Appeal Decision

Appeal Ref: APP/R5510/W/21/3286382

34 Acacia Avenue, Ruislip, HA4 8RG

- The appeal is made under section 78 of the Town and Country Planning Act 1990 against a refusal to grant planning permission.
 - The appeal is made by Panoramic Developments Ltd against the decision of London Borough of Hillingdon Council.
 - The application Ref 1788/APP/2021/3141, dated 12 August 2021, was refused by notice dated 25 October 2021.
 - The development proposed is 1no. detached 4-bed dwelling house and 2no semi-detached 4-bed dwelling houses.
-

Drawing Title  
**SITE PLAN AND  
DETAILS**

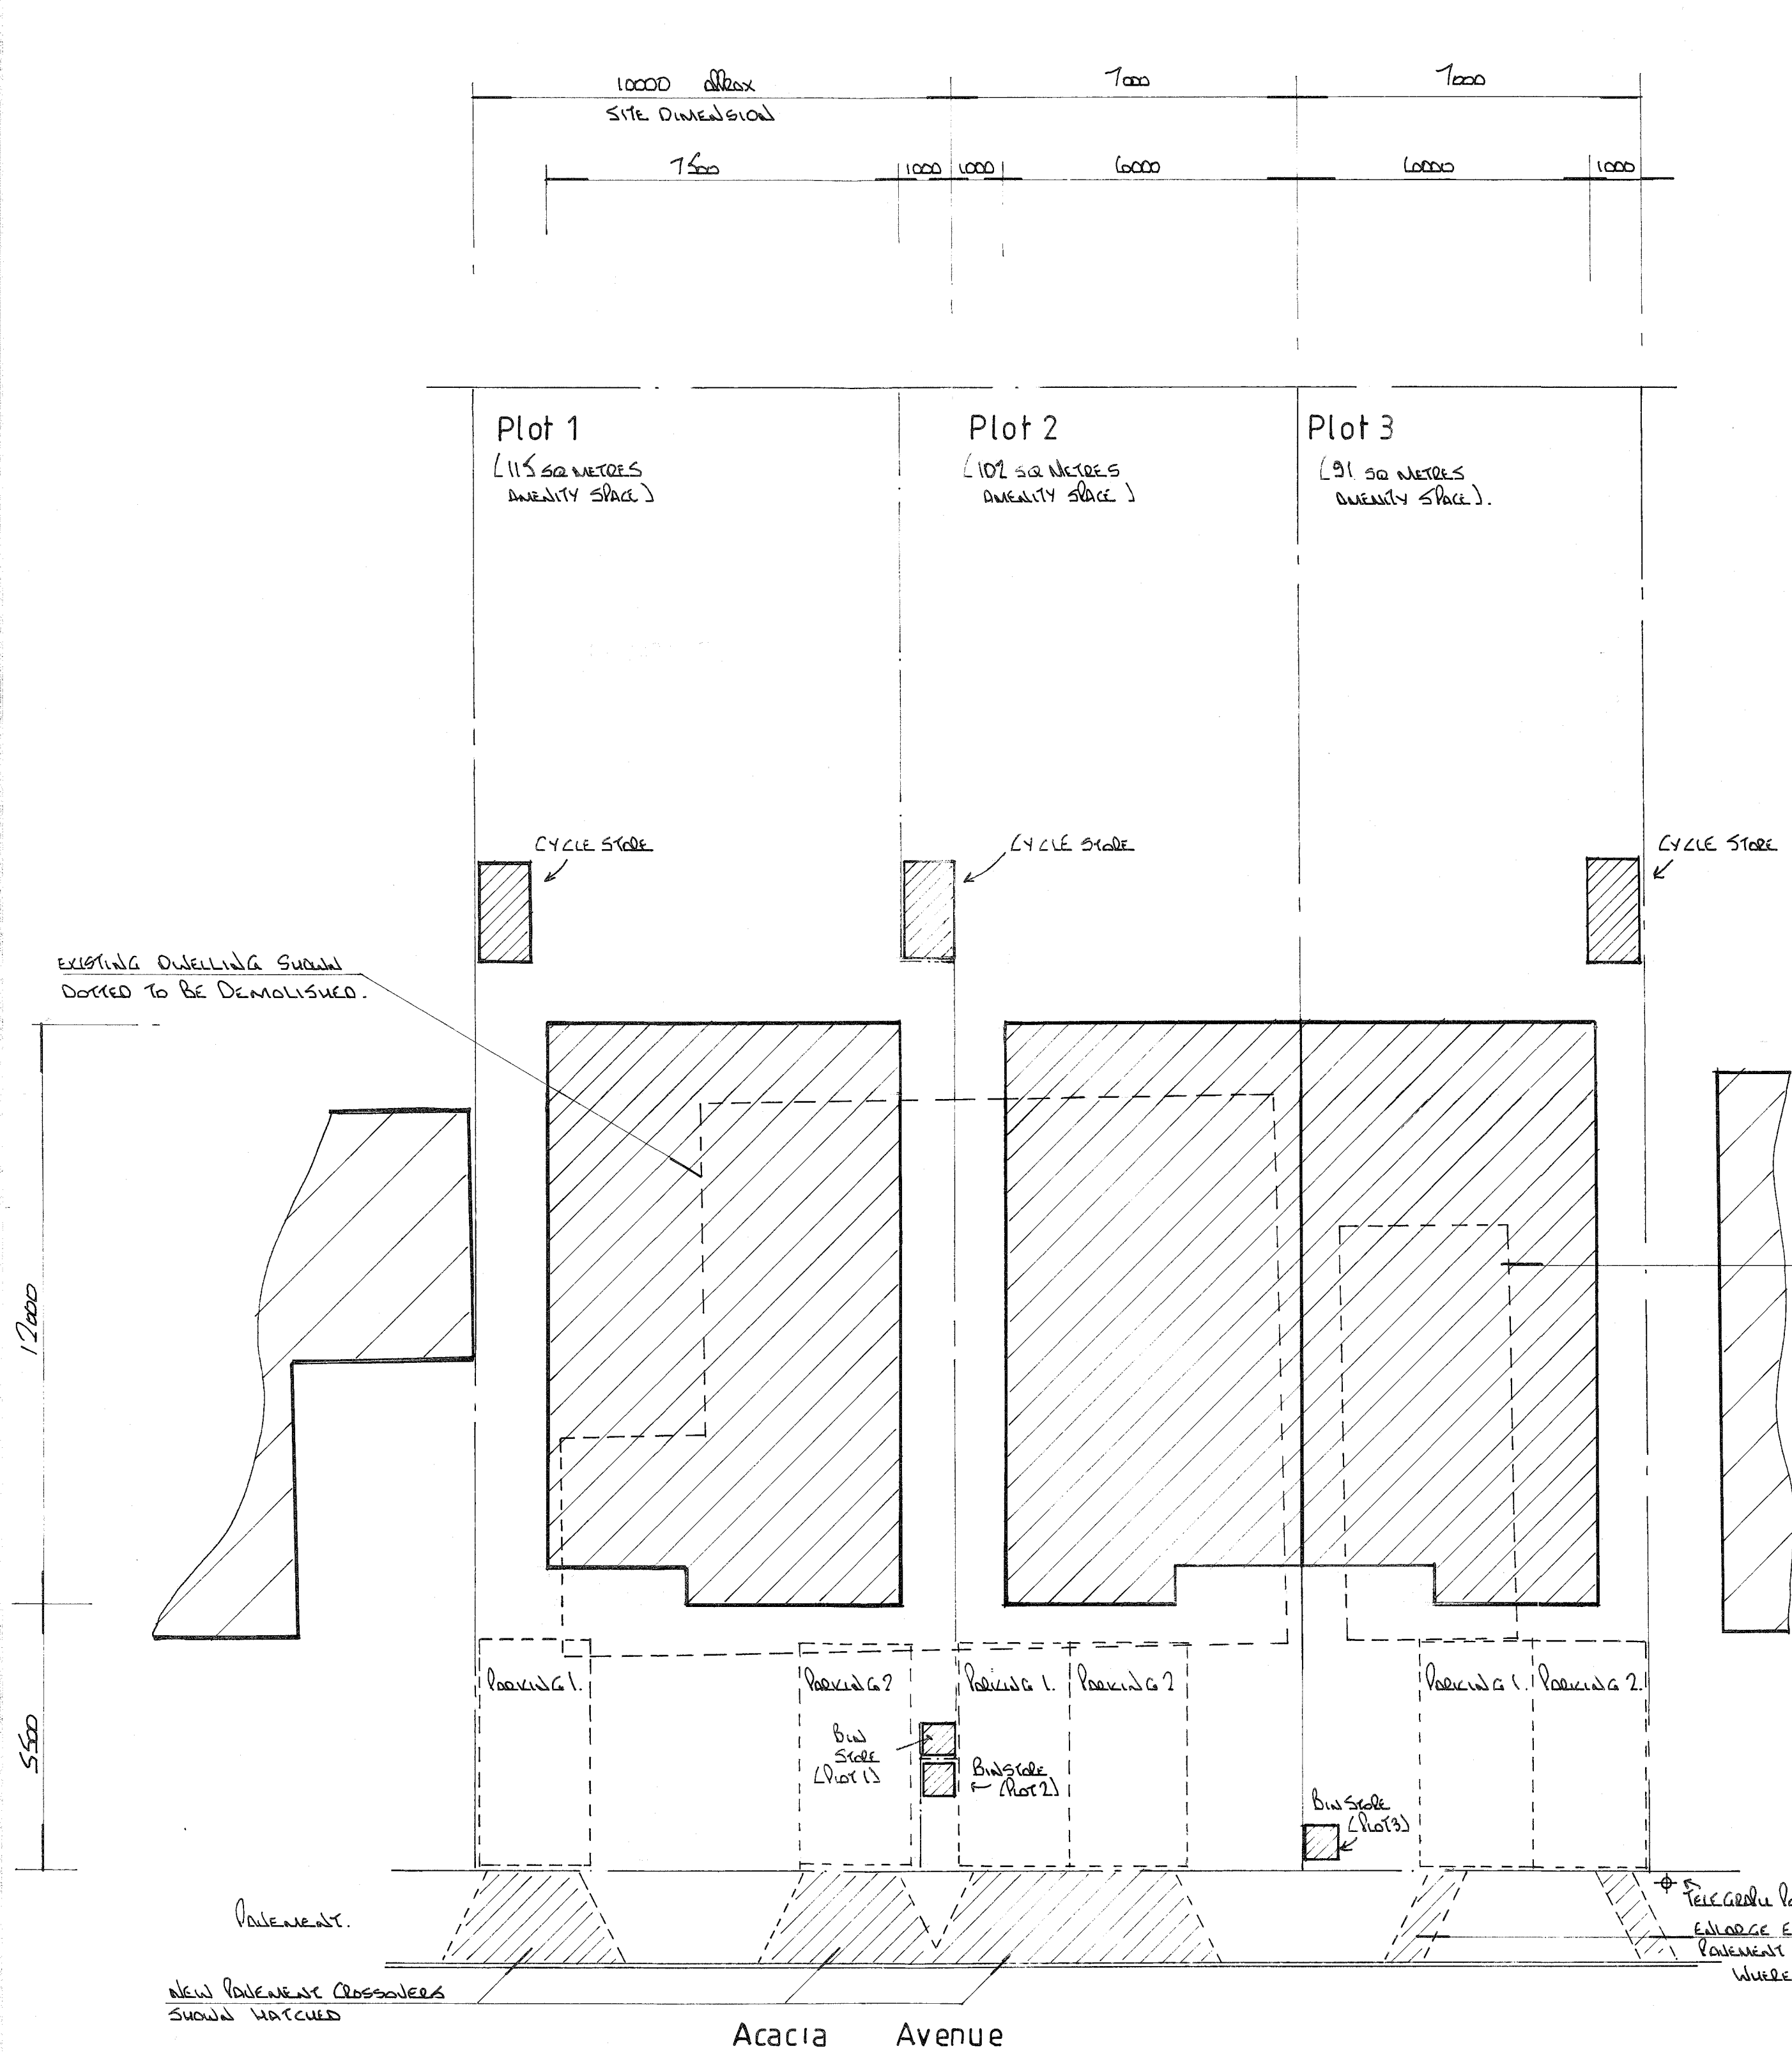
12. Specific Council policy guidance refers to external space size for occupants. A four bedroom dwelling requires a minimum standard of 100sqm although the dwelling on Plot 3 has been specified on the submission to provide approximately 91sqm of private amenity space for future occupants.
13. The appellant points to other houses on the same road that they consider to be commensurate in rear garden space size. However, the precise size is not before me to compare and in any case, the proposal at appeal is for a new

14. Given the size of external space for future occupants that fails to meet the required level, the proposal would not comply with Policy DMHB 18 of the Hillingdon Local Plan: Part Two - Development Management Policies 2020 that aims to provide quality external space.

Drawing Title
**PLOTS 2 & 3
FLOOR PLANS AND
ELEVATIONS**

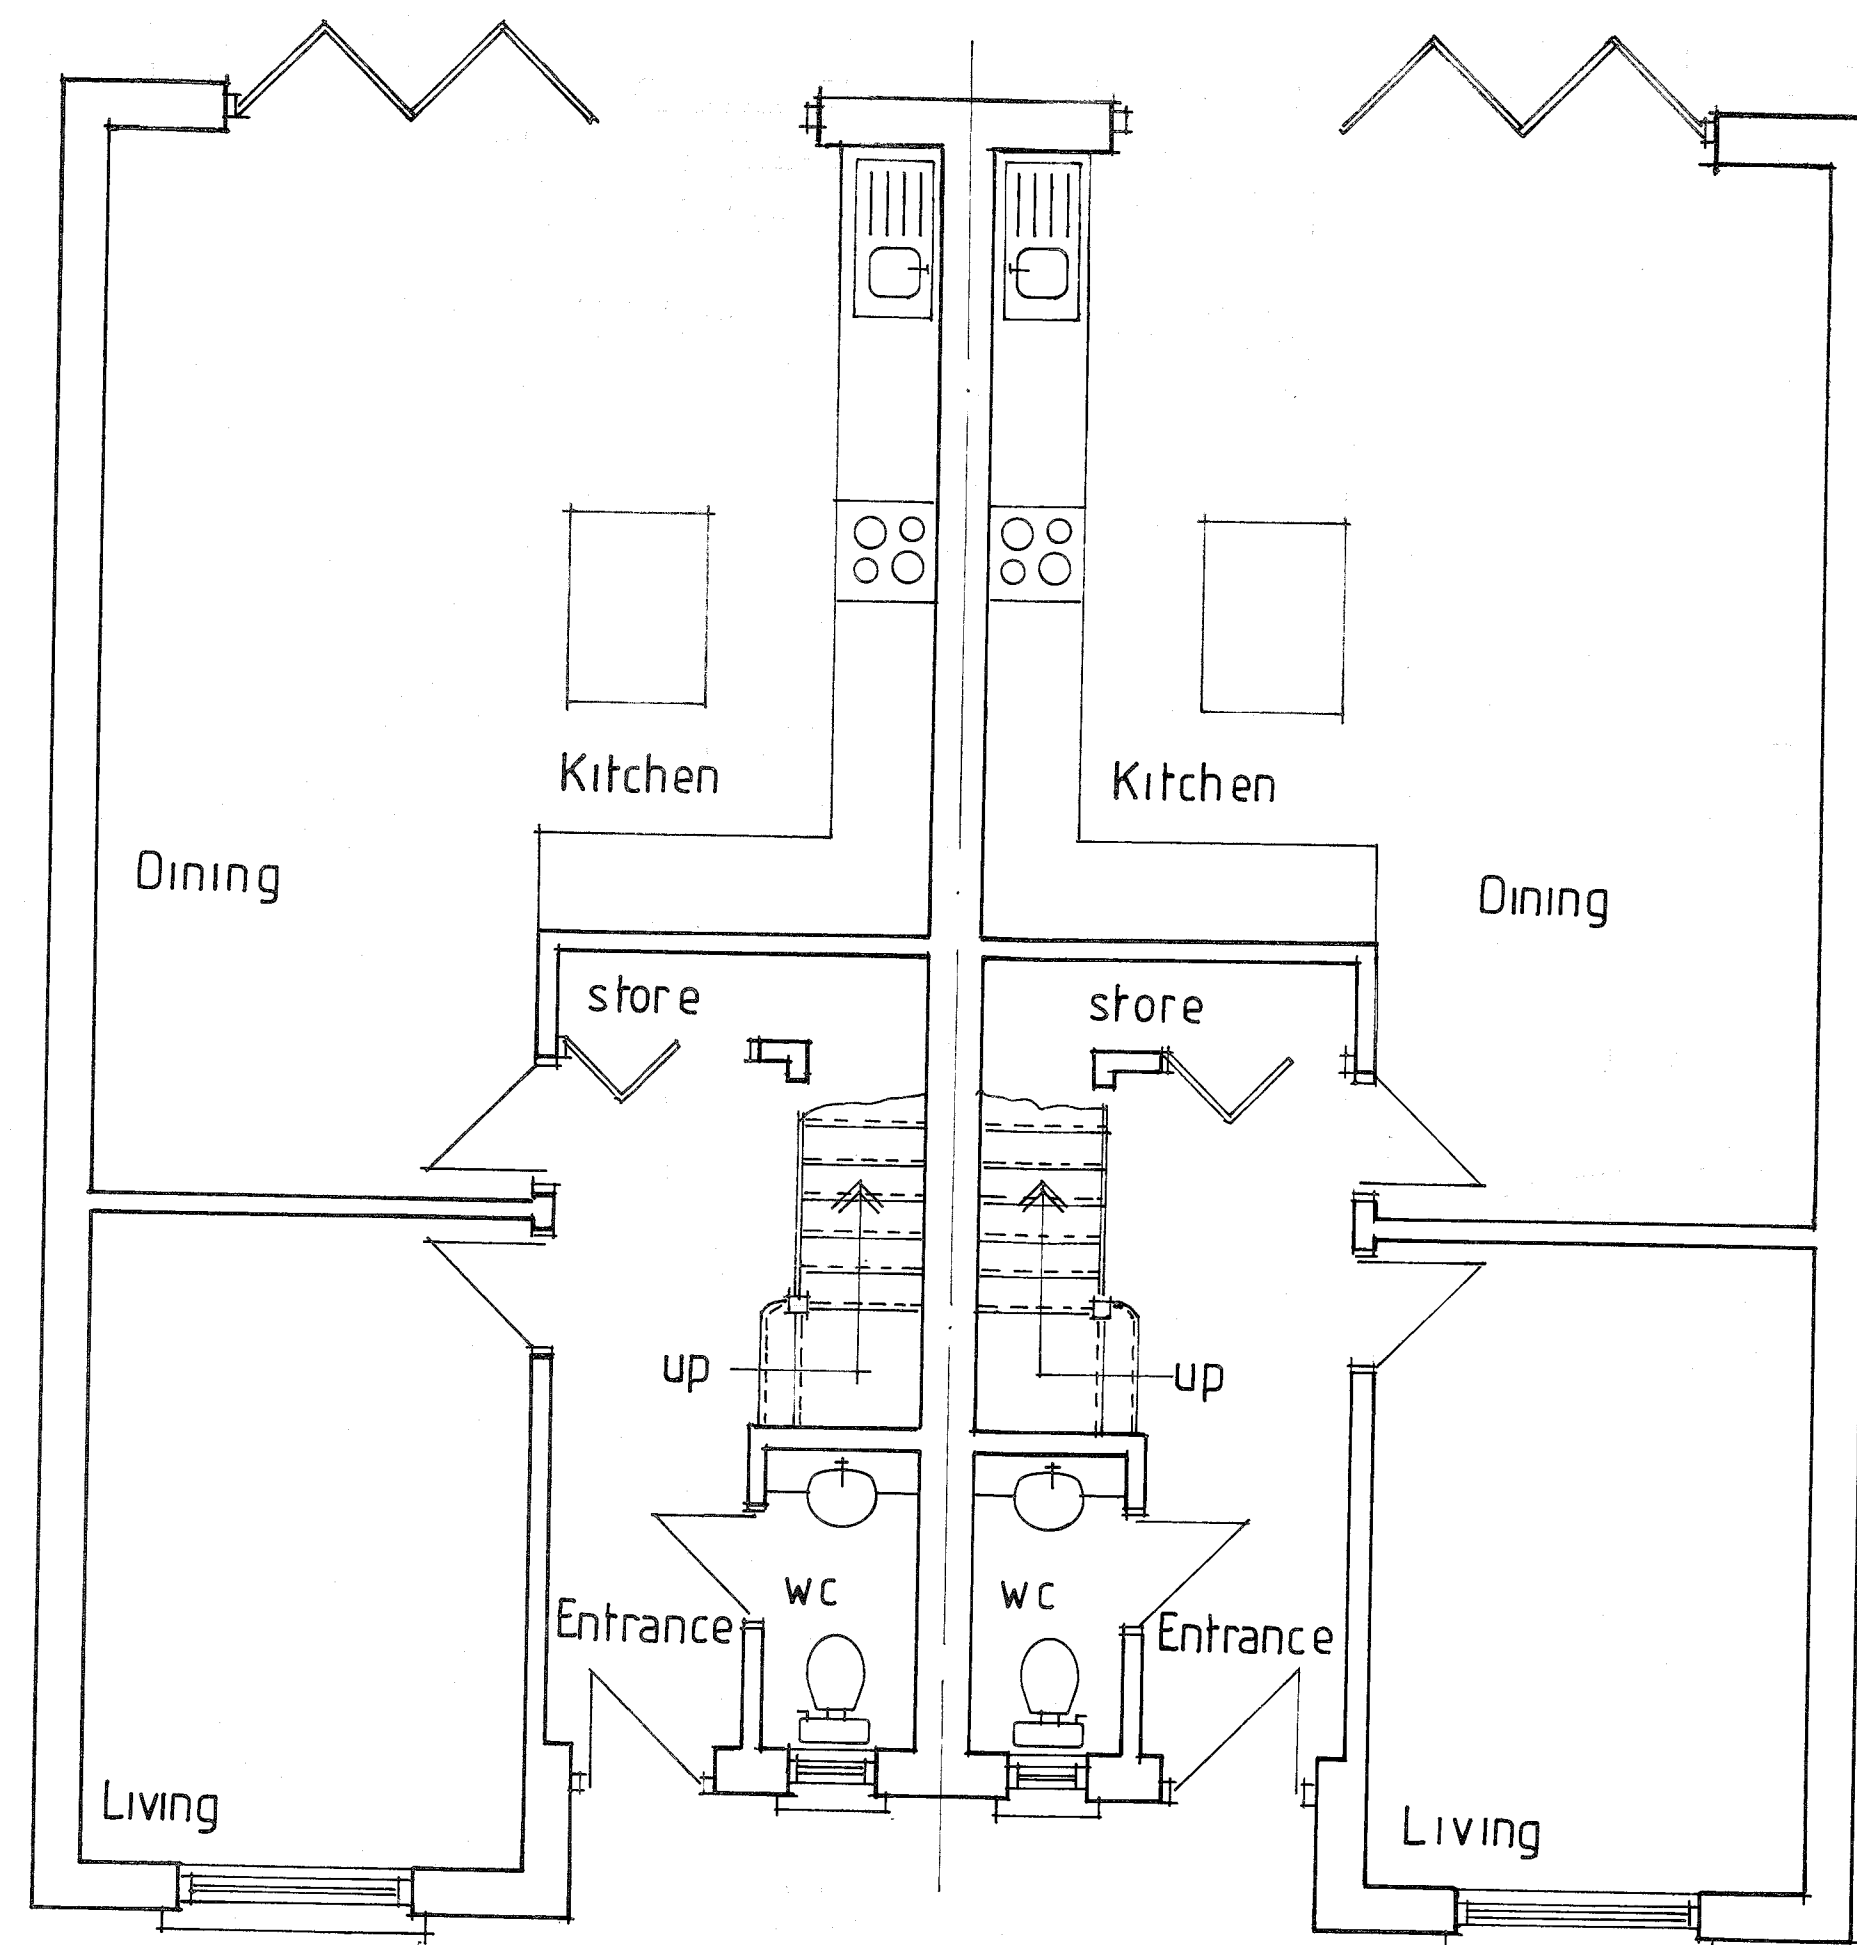
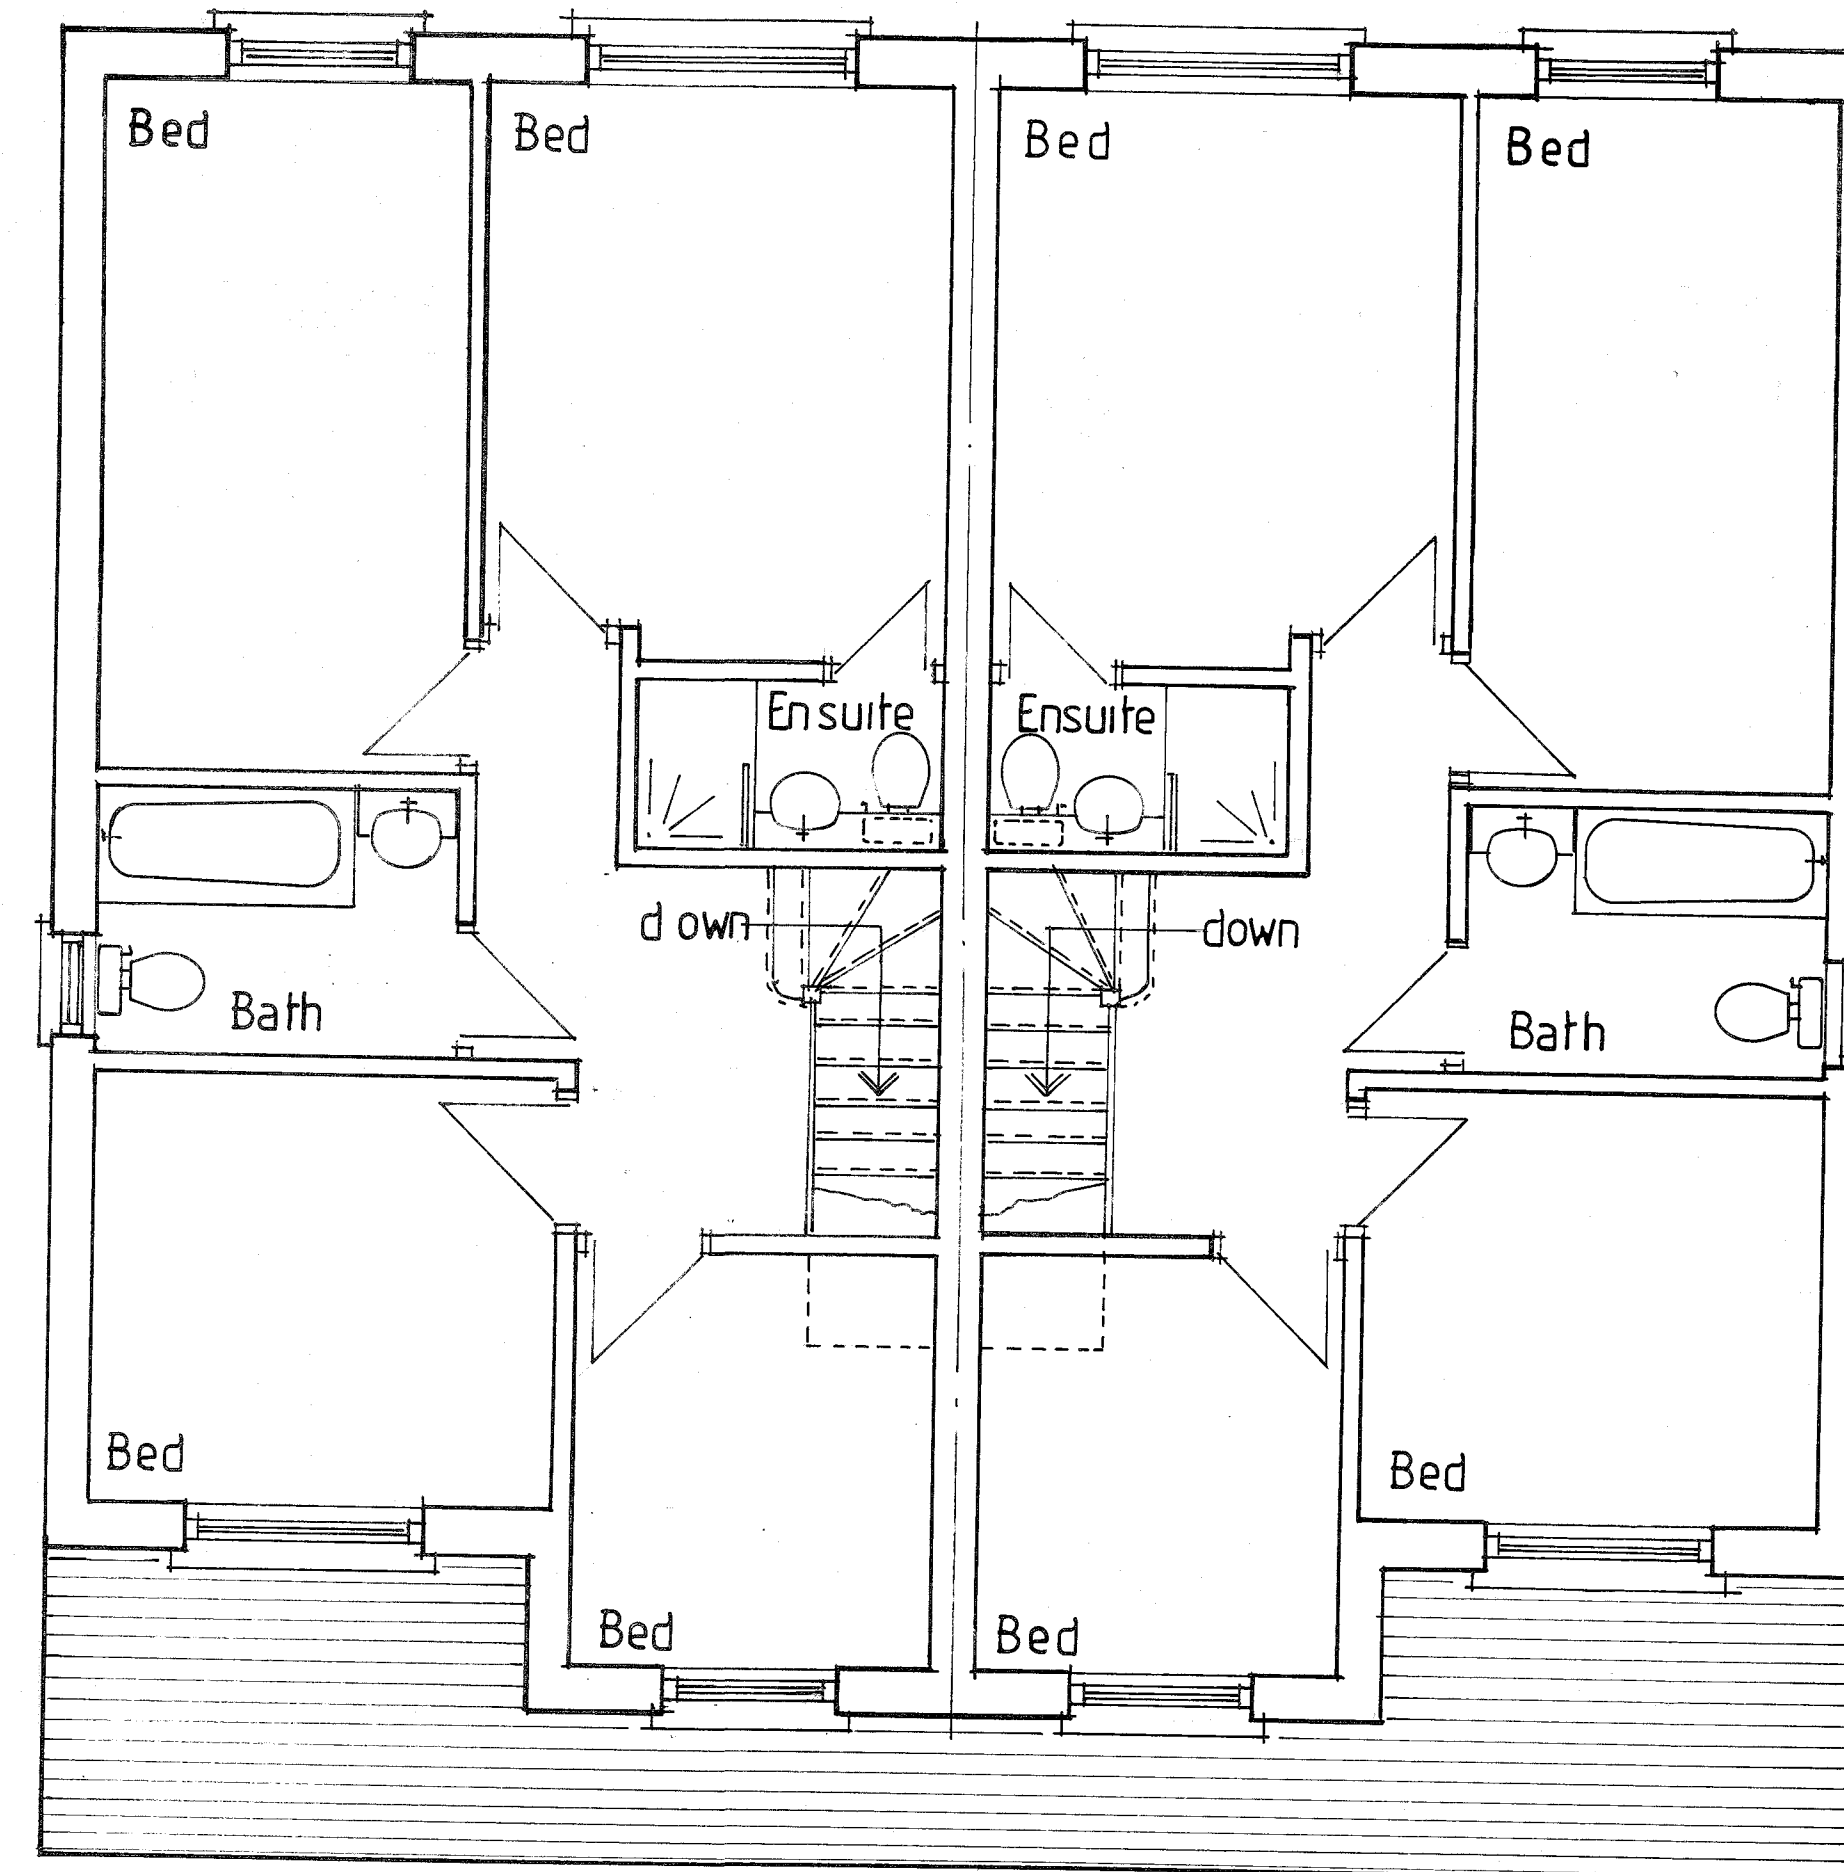
8. The London Plan 2021 sets out the minimum internal space standards for new dwellings within London. The houses in plots two and three have bedrooms that do not comply with the standard. I attach great weight to this Plan.

9. The appellant may consider these houses would provide more generous overall footprint, and larger than other new builds within the local area. Nonetheless, these matters are not sufficient justification as to why their scheme cannot meet these standards, which are minimum standards. Even if the dwellings would be built to Building Regulations requirements, and they may be more energy efficient than the existing bungalow, these matters would not off-set room sizes that do not meet policy requirements, and the adverse consequence of such on the living conditions of future occupiers.

11. Therefore, to conclude on this main issue, due to the identified below minimum room size standard, the proposal would not meet the policy requirements of D6 of the London Plan 2021 to ensure housing quality and standards.
